Final Plat_V1.PDF Markup Summary

Terra Benedetta Subdivision

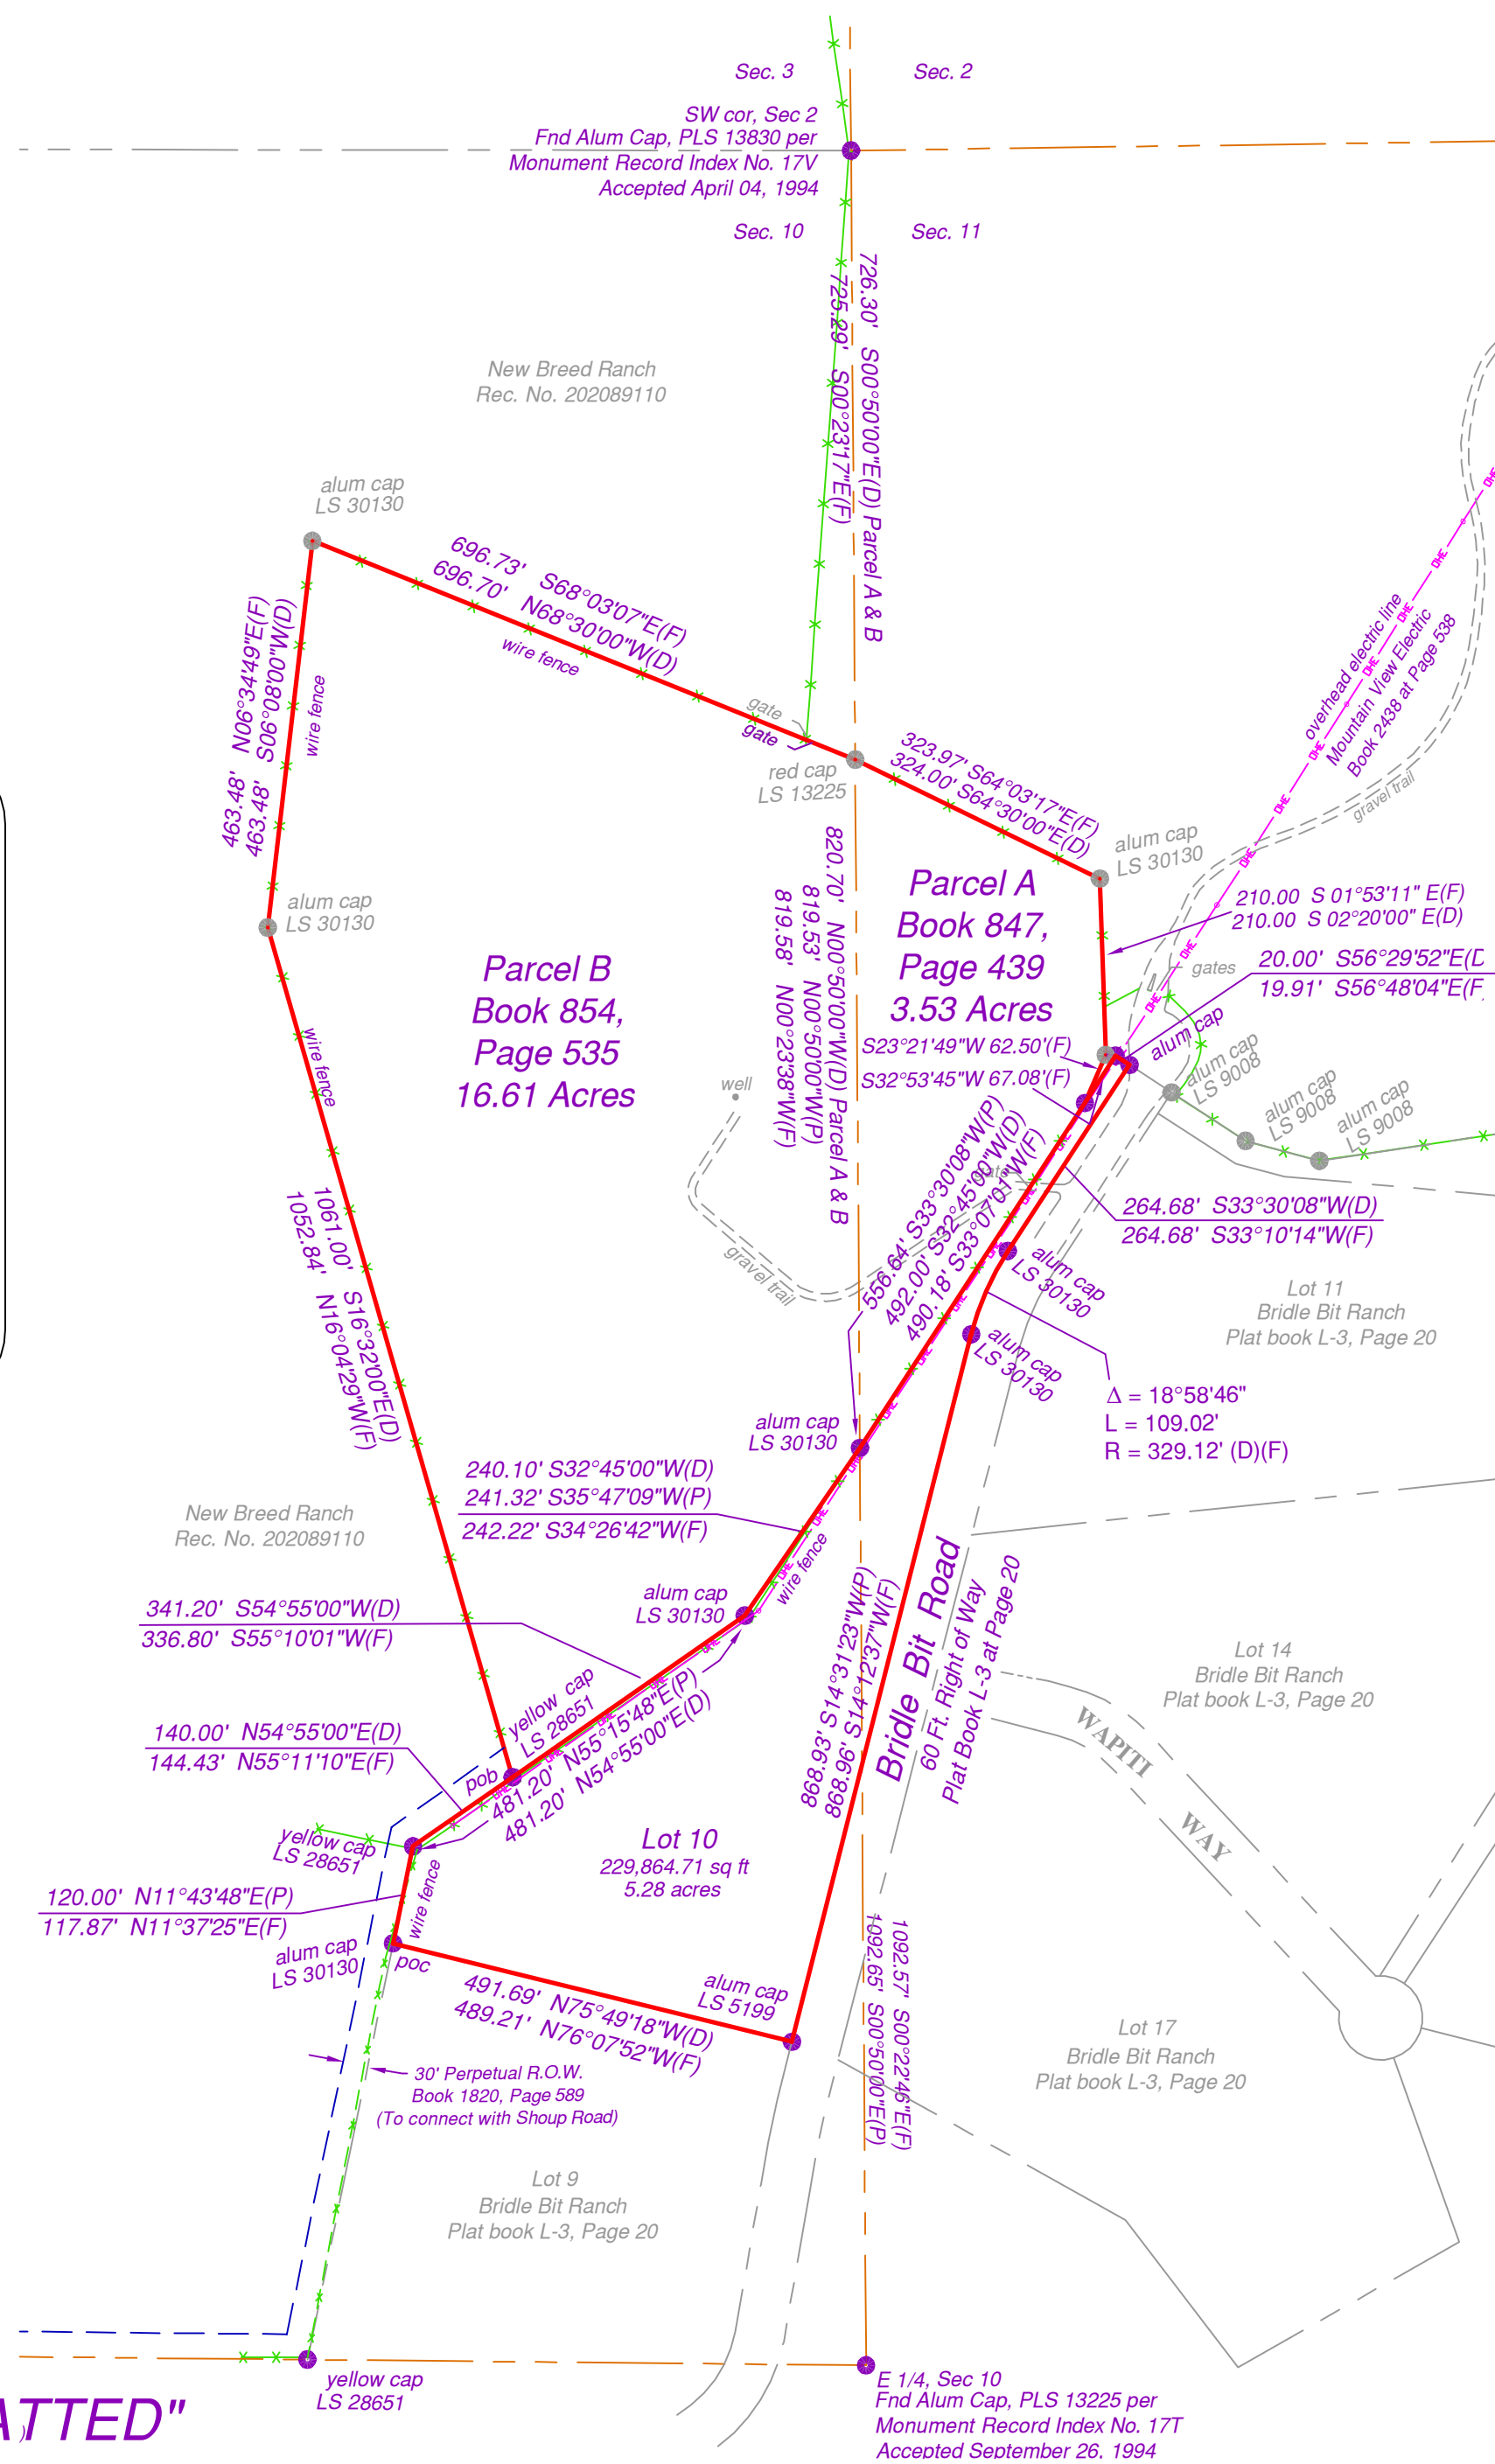
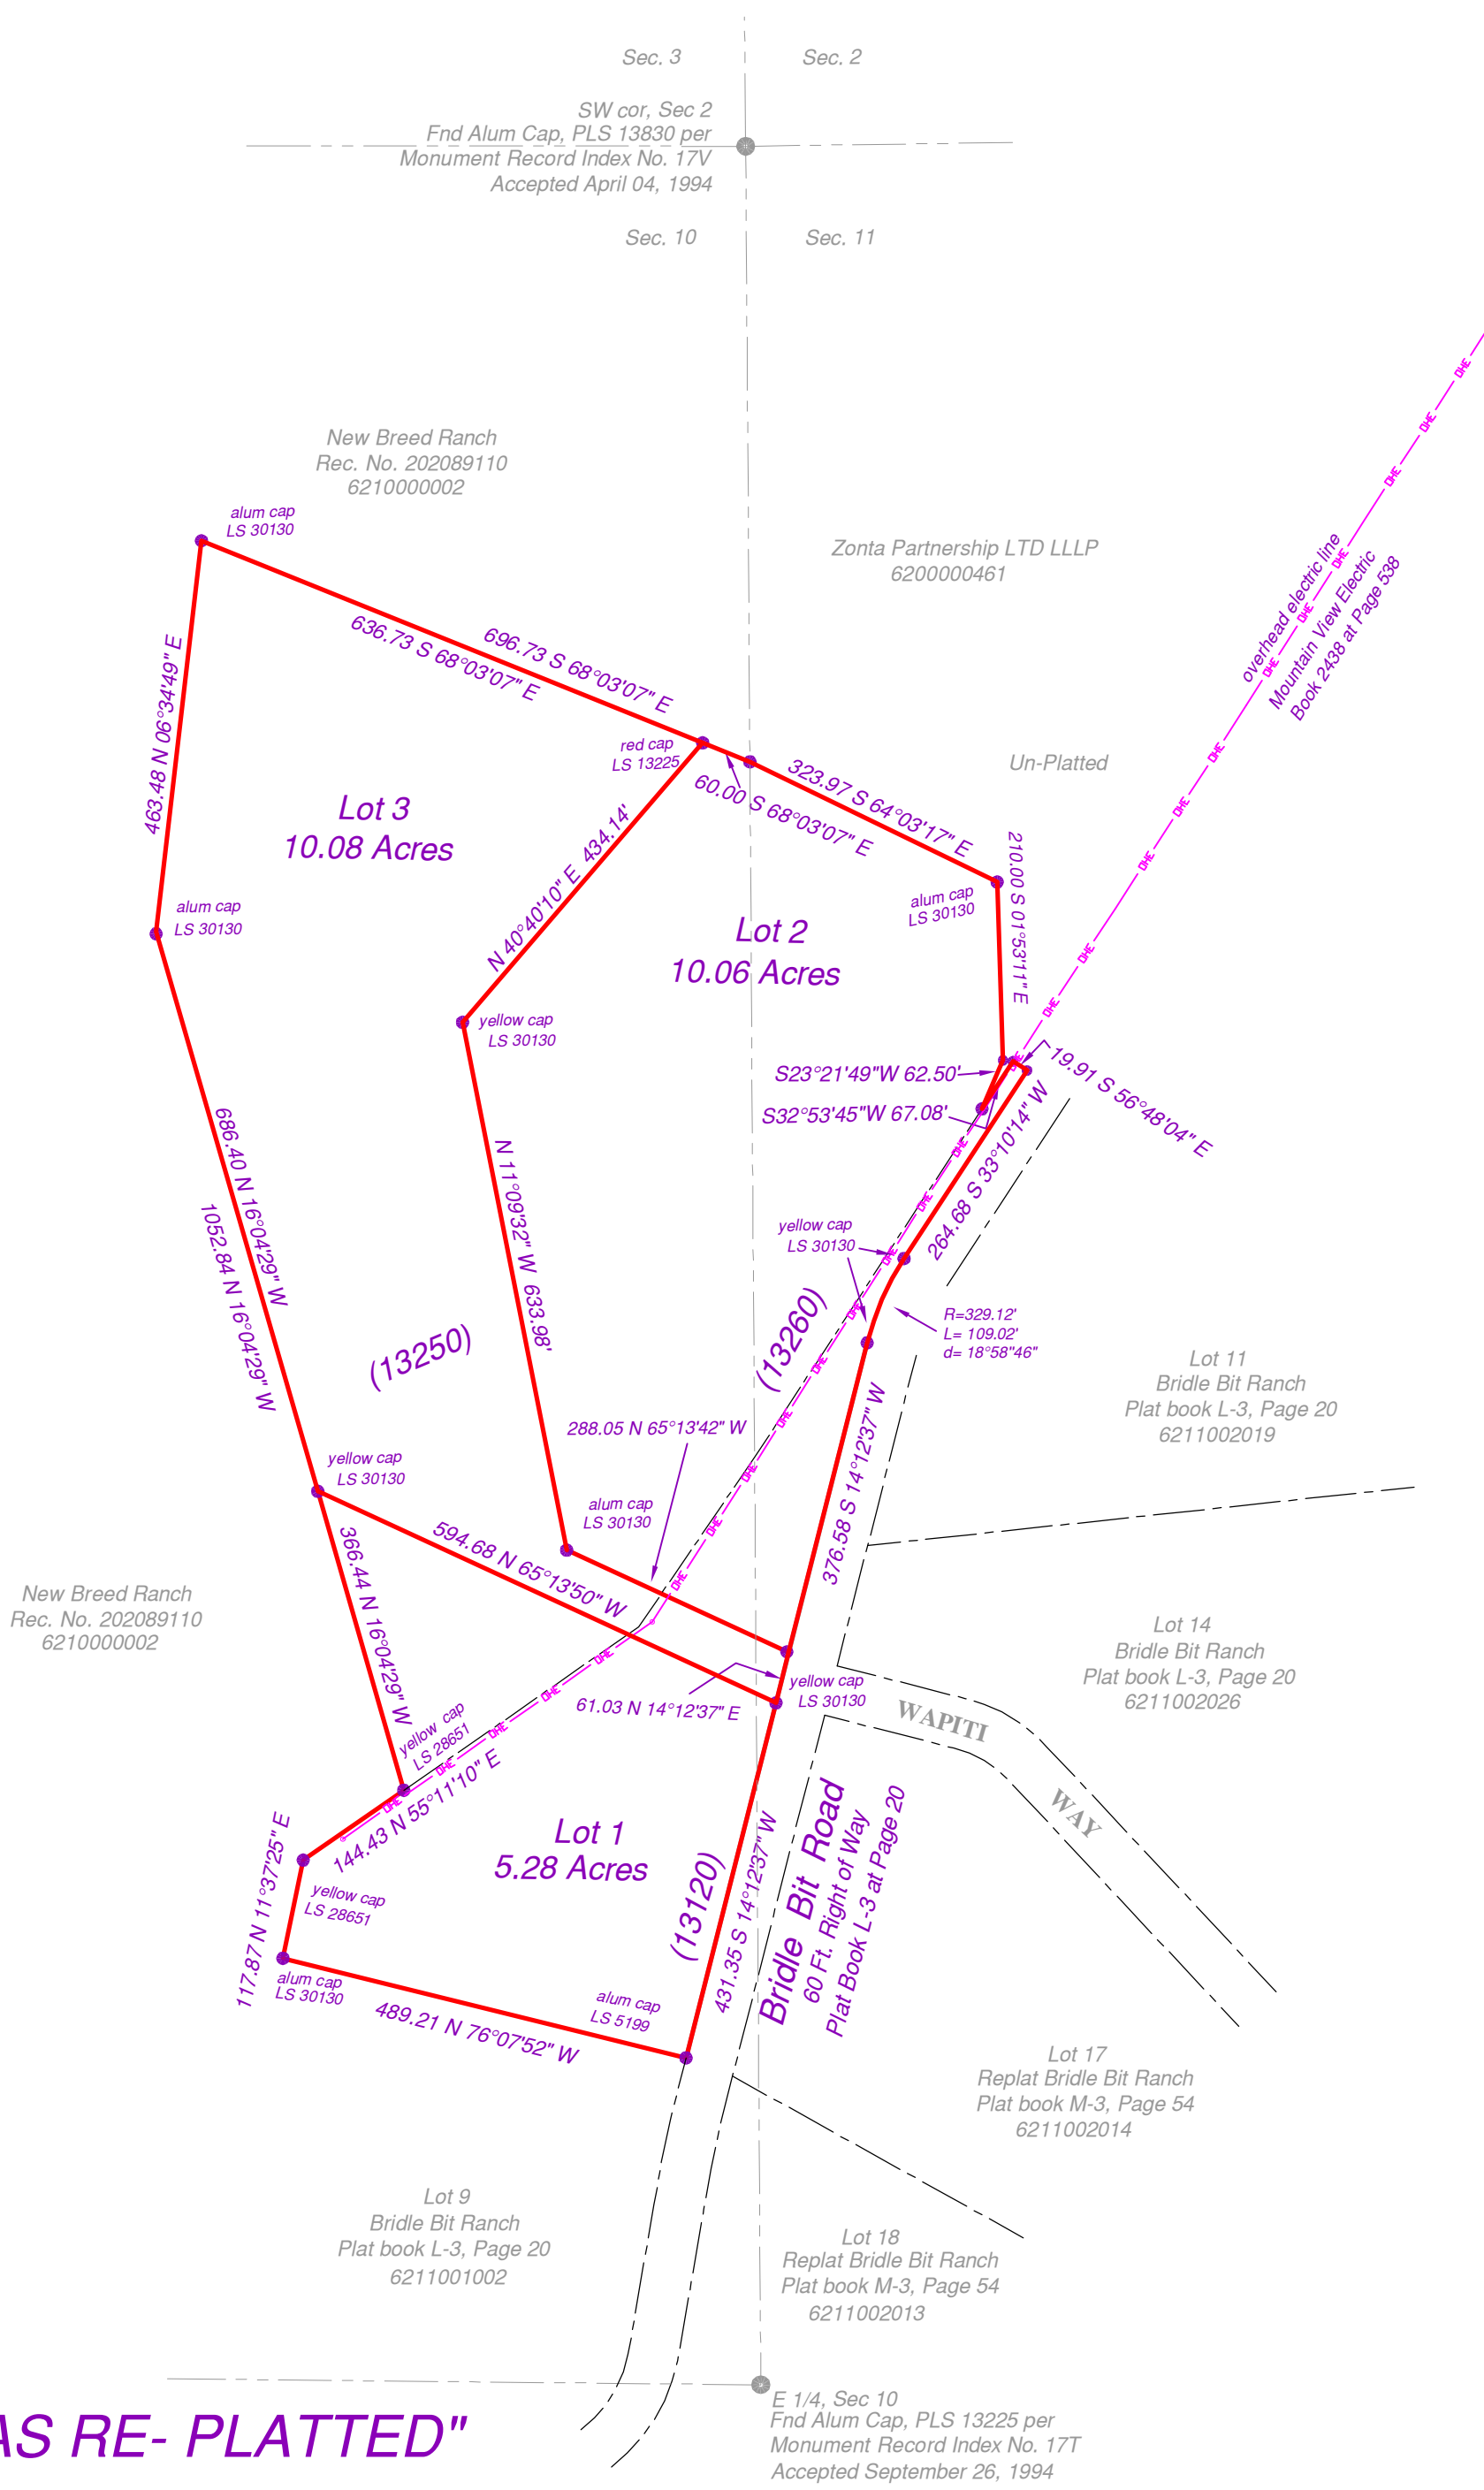
duplicate

Revise to "Clerk and Recorder"

Revise to "Clerk and Recorder"

Please revise this certificate to indicate only PCD Director's approval. No BOCC approval for this plat; please remove

Indicate ROW width for each road

the water supply's well information for the 3 lots will need to be revised accordingly per comment from State DWR requiring revised well permits per an augmentation plan.

Please show all easements on plat.

Please add "PCD File No. VR-21-06".
